Our Ref: PDJB/2379/02

13 February 2024

**PLANNING APPLICATION – 1 MOORCROFT PARK DRIVE, NEW MILL, HOLMFIRTH HD9 1JH**

client	MR AND MRS NORGATE		
project	PROPOSED EXTENSION TO 1 MOORCROFT PARK DRIVE, NEW MILL, HOLMFIRTH, HD9 1JH		
drawing	PROPOSED PLANS, ELEVATIONS AND VISUALS		
revision	notes	date	drawn
A	AMENDED PROPOSAL	02.25	JH
scale :	1:50 & 1:100 AT A1	09.24	PB
project no.	drawing no.	revision	
2377	03	A

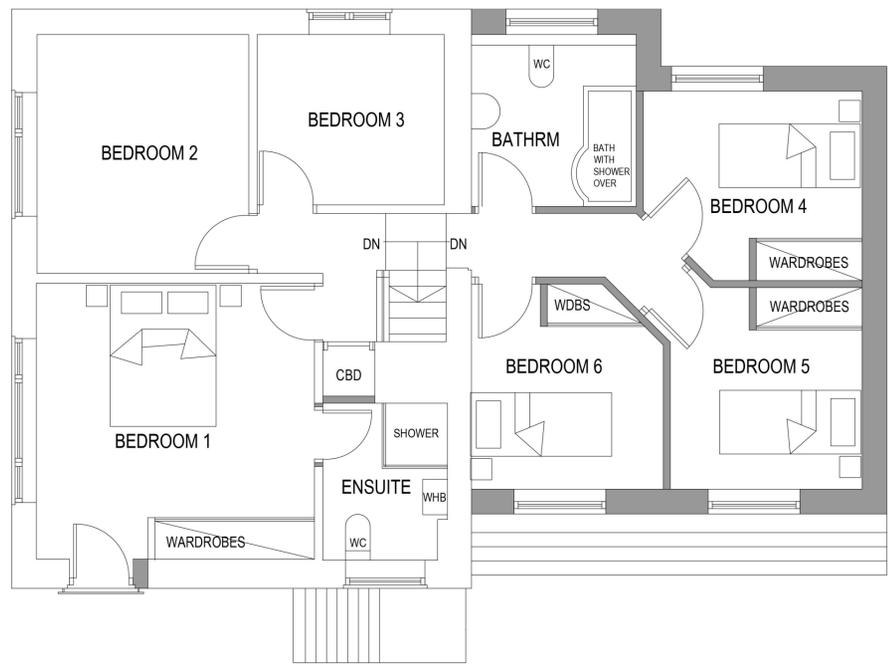
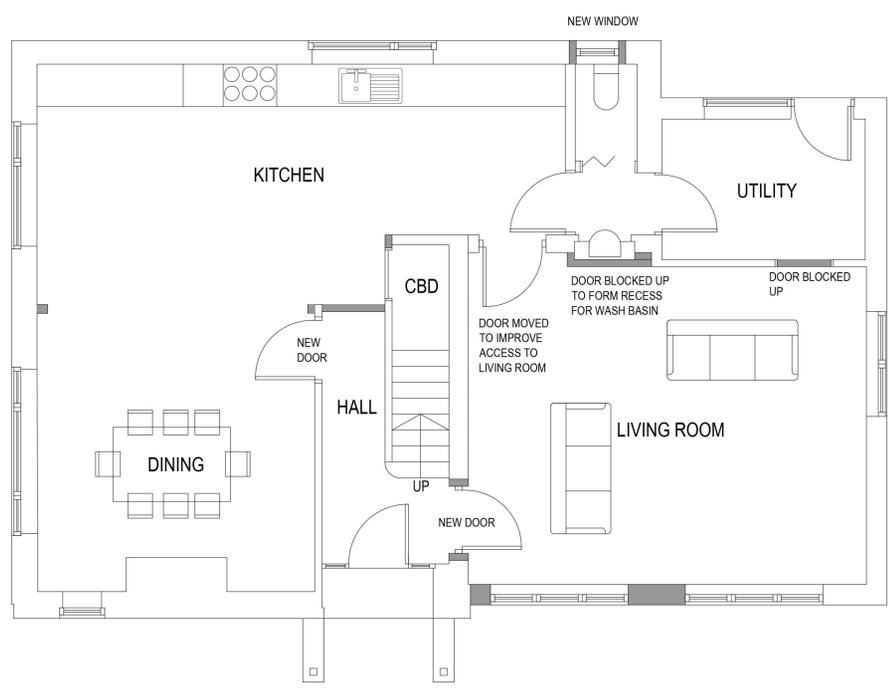
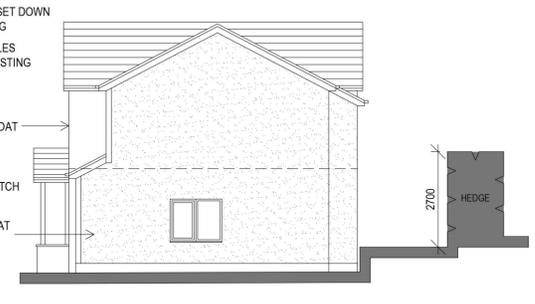
The proposals included a first floor extension which was rendered to the rear and side, and stone to the front. The applicants are proposing to continue this render around the first floor of the extension and into the existing house corner. This is a characteristic of houses along Moorcroft Park Drive, so this amendment will not appear obtrusive.
